DELEGATED REPORT

APPLICATION NUMBER	S6/2004/0873/FP and S6/2004/0849/LB
LOCATION	The Accommodation Block, Astwick Manor, Coopers Green Lane, Hatfield
PROPOSAL	Conversion of building into one 1 bedroom and five 2 bedroom apartments with 12 parking spaces

Drawing number
24903/101

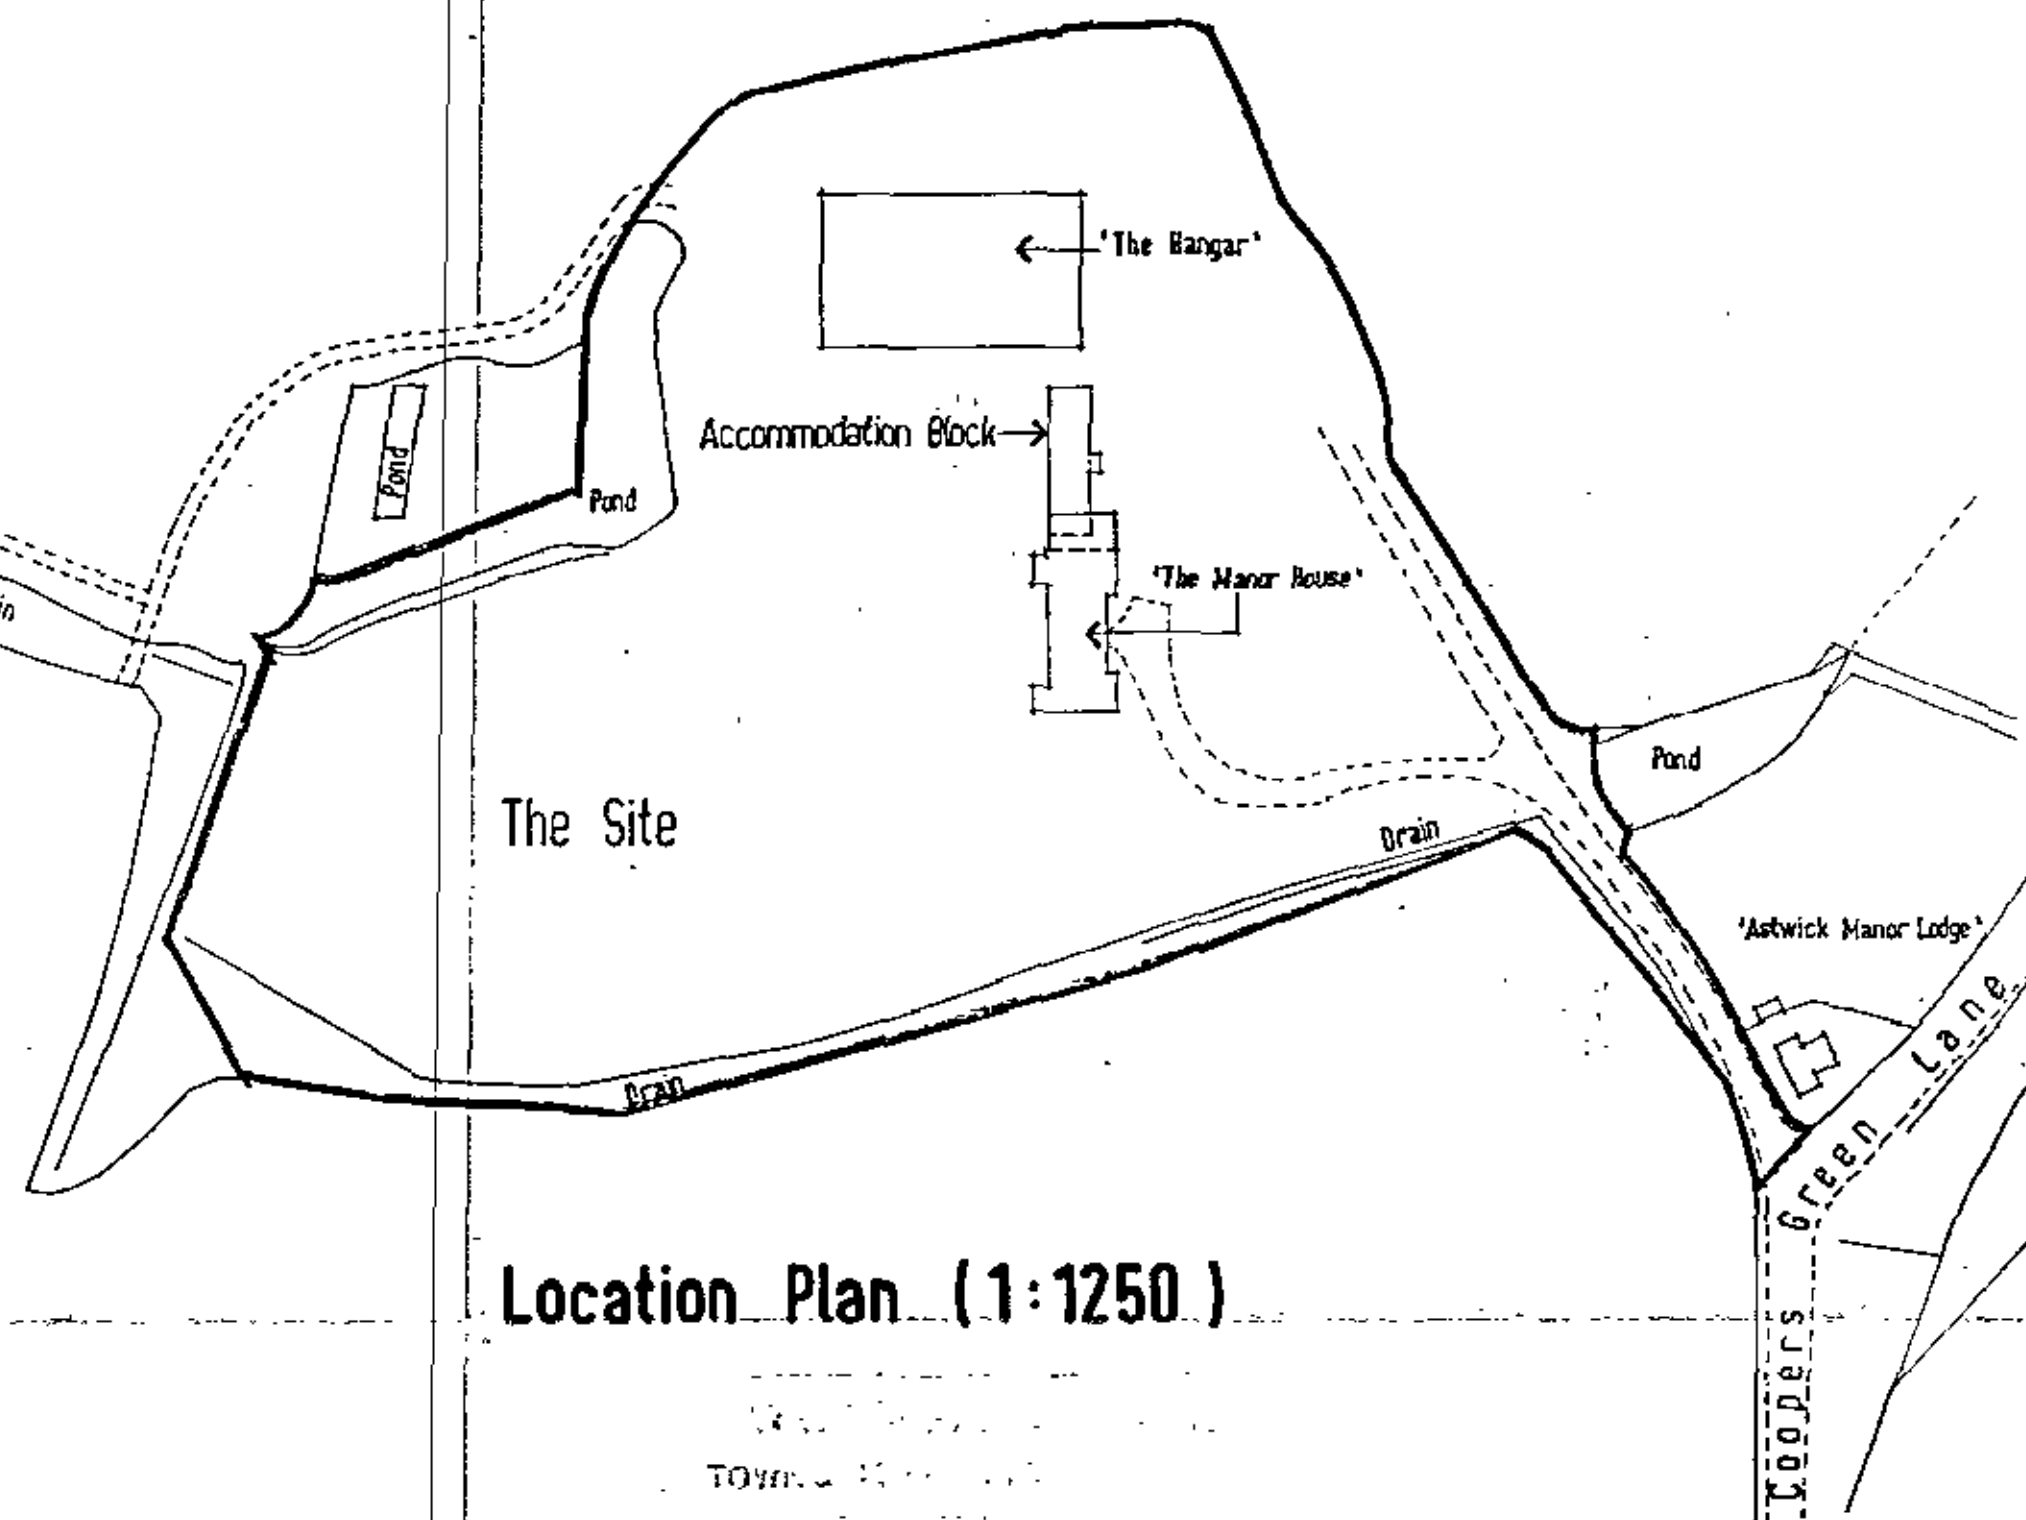
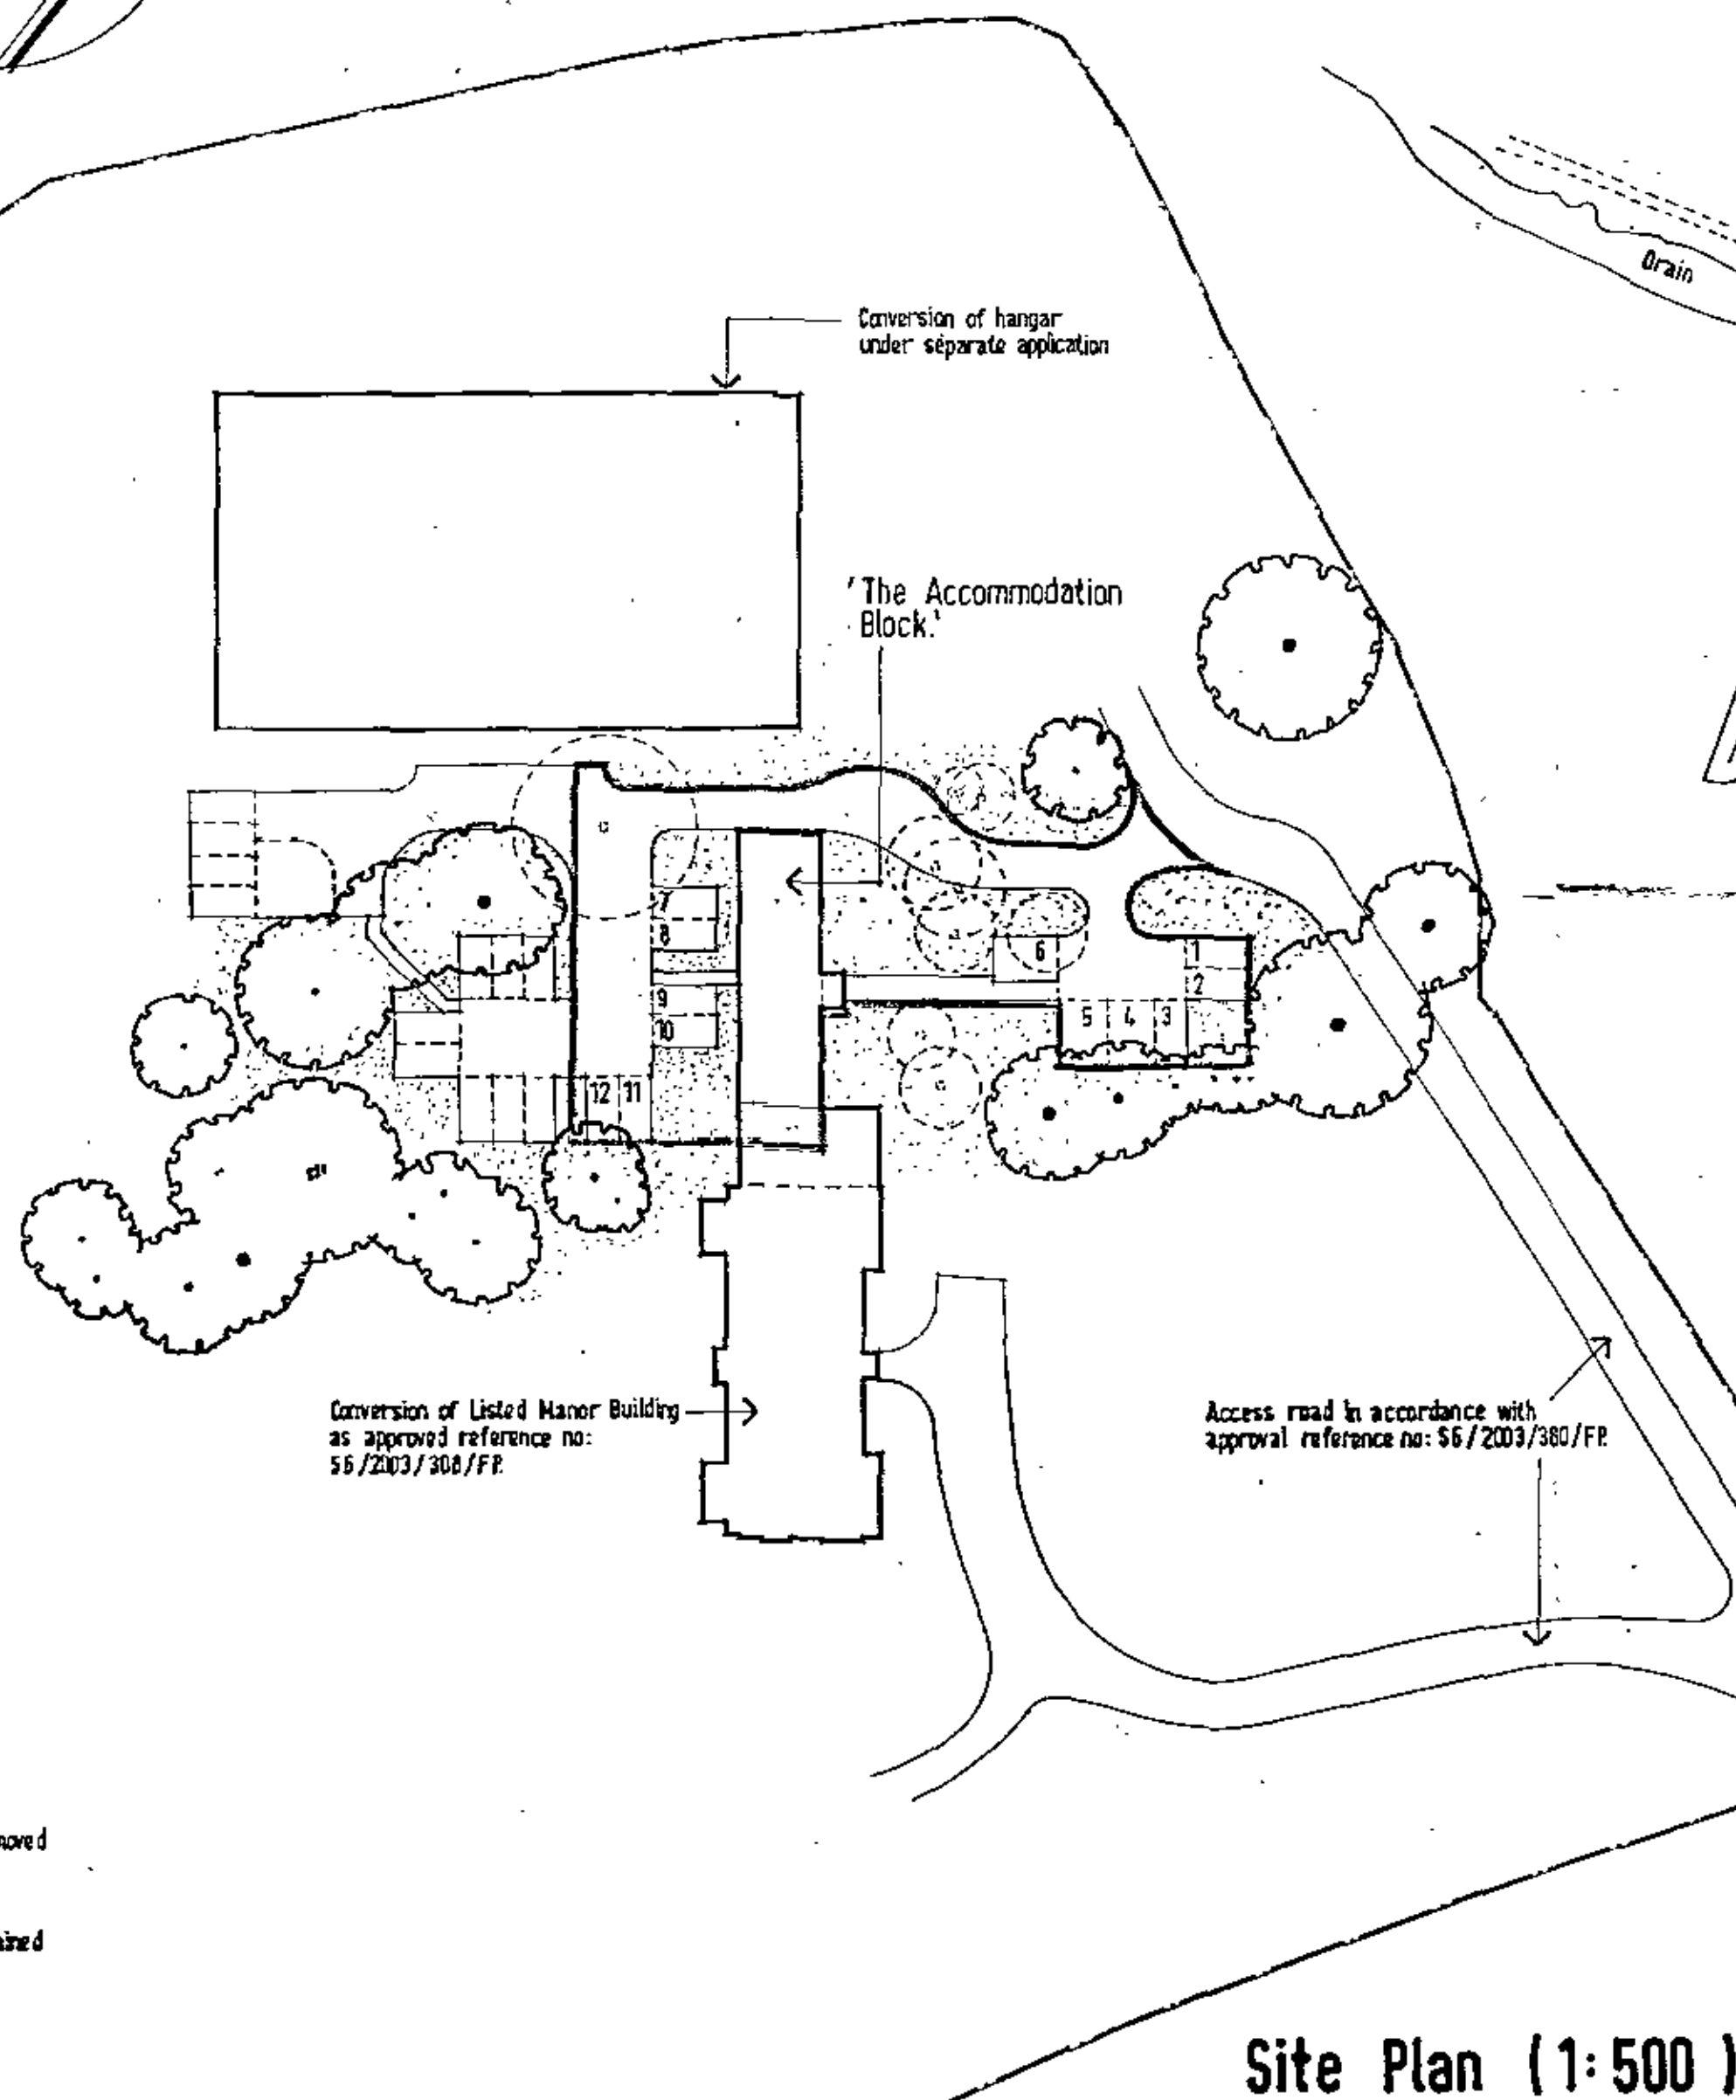
- Internal layout modified from that approved by S6/2003/380/FP (NB no additional residential units proposed)
- Parking for 12 cars to be as indicated on drawing 24903/101

Traffic, Highways and Parking - the application seeks approval of 12 car parking spaces to be located in new parking areas. Condition 6 imposed on S6/2003/380/FP required a scheme for a less formalised approach to parking to be submitted to and approved by the LPA. The parking arrangement proposed for the accommodation block (drawing no 24903/101) is considered acceptable. This scheme will not represent a change to the previously approved access arrangements but will not supersede the requirement for improvement works to be carried out to the junction between the access road to the site and Coopers Green Lane. For the purposes of consistency and to prevent implementation of a consent without the necessary road junction improvements, Condition 3 of S6/2003/380/FP is to be imposed here.

3. The parking spaces shown on the plan hereby approved shall be provided and marked out prior to the occupation of any buildings on the site, and shall be retained and kept available for those purposes thereafter.
